MECKLENBURG COUNTY
Park and Recreation Department

MEMORANDUM

DATE: December 19, 2007

RE: Rezoning Petition # 2008-035 (PID #s 075-105-43; 075-105-30; 075-105-37;
079-044-02)

VICINITY MAP
Not To Scale

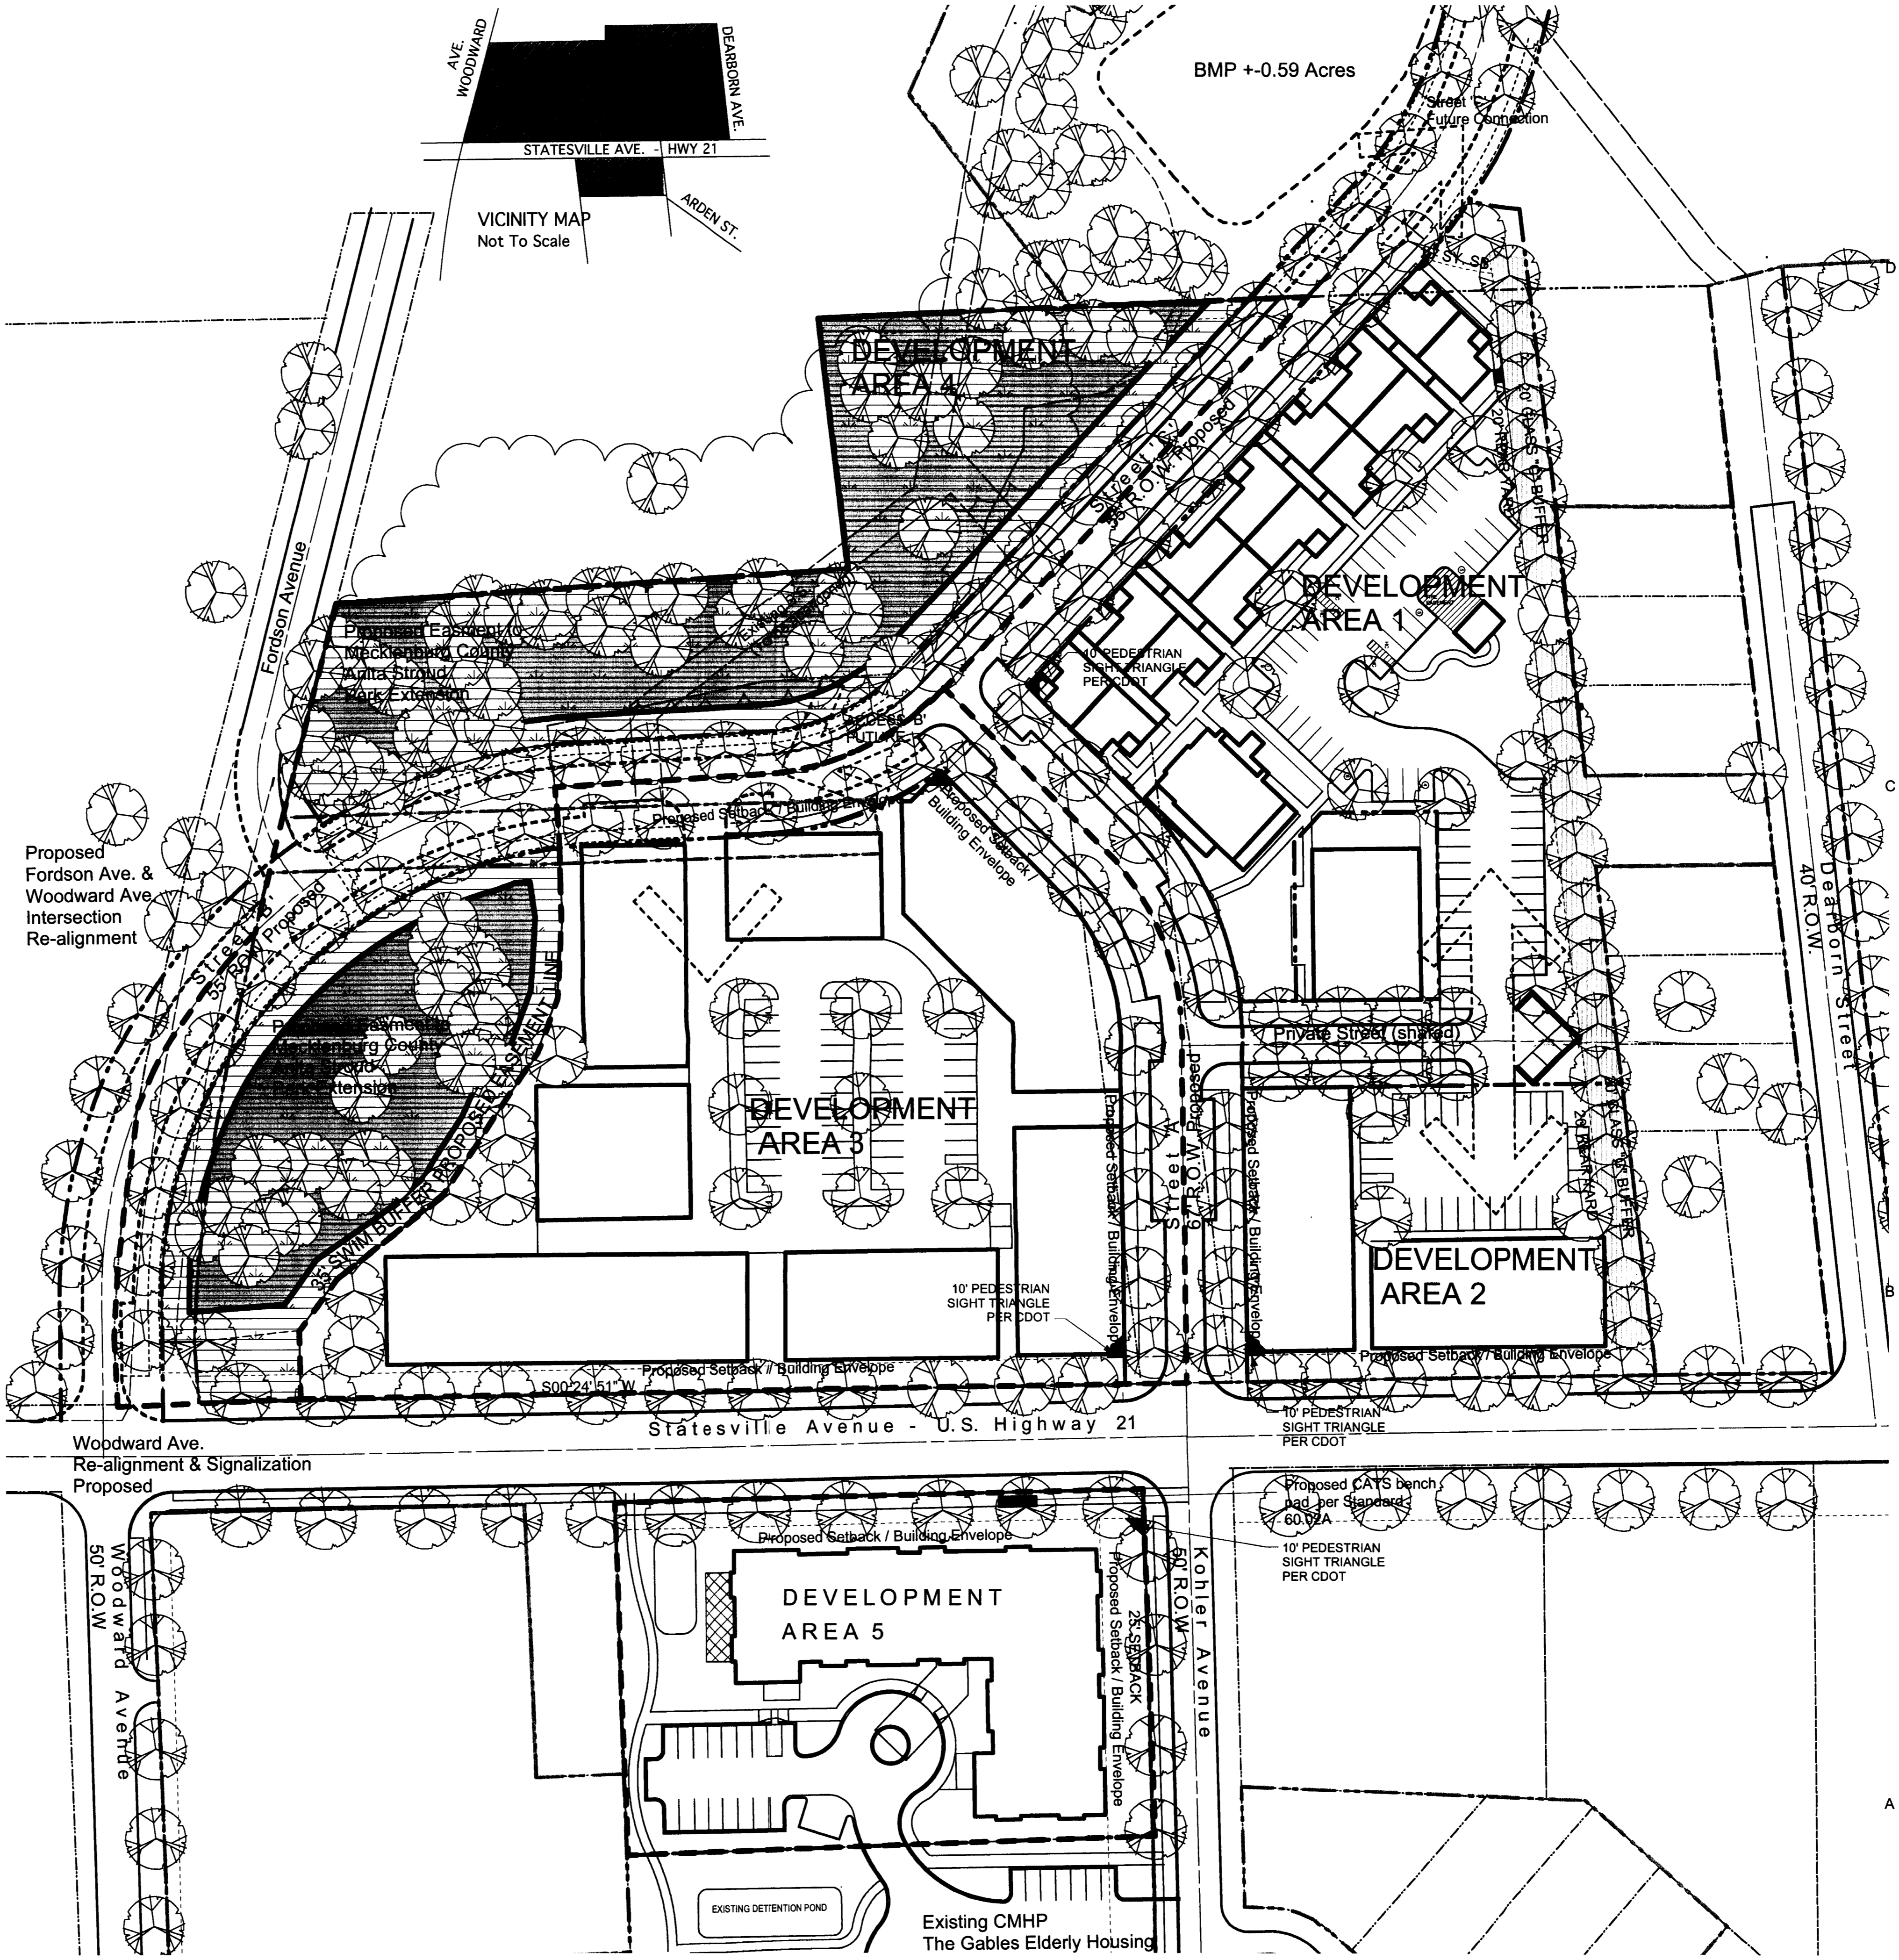
In most cases MCPR requests that the petitioner dedicate the FEMA floodplain or S.W.I.M. buffer to the County for floodplain protection and greenway development. On the site plan dated 11/9/07, the petitioner has offered an easement encompassing the 35' SWIM buffer. MCPR is appreciative of this offer. However, this site presents challenges that require additional easements or dedications for a greenway to be constructed. MCPR requests an easement or dedication of the entire area of "Development Area 4" that is on the northern side of the proposed Woodward Avenue. This will provide additional area to route the greenway and also allow for a connection to the public sidewalk system at the intersection of Woodward Avenue

and Kohler Avenue. Additionally, MCPR requests that the reconstructed Woodward Avenue bridge over the Irwin Creek tributary be built to accommodate an 8' wide greenway trail with a minimum clearance of 7'6" underneath the bridge on the eastern side of the tributary. MCPR also requests an easement or dedication of additional land at the intersection of Woodward Avenue and Statesville Avenue to enable the greenway to fully reach the intersection. The additional dedication should be a minimum of 180 square feet and should form a straight line between the 35' SWIM buffer easement line and Statesville Avenue as shown on the site plan.

MCPR also wishes to note that additional land outside of the area encompassed in this rezoning will be required to connect the proposed easements to Anita Stroud Park. This approximately 200' gap exists north of the area entitled "Development Area 4" and adjacent to the proposed BMP as shown on the site plan.
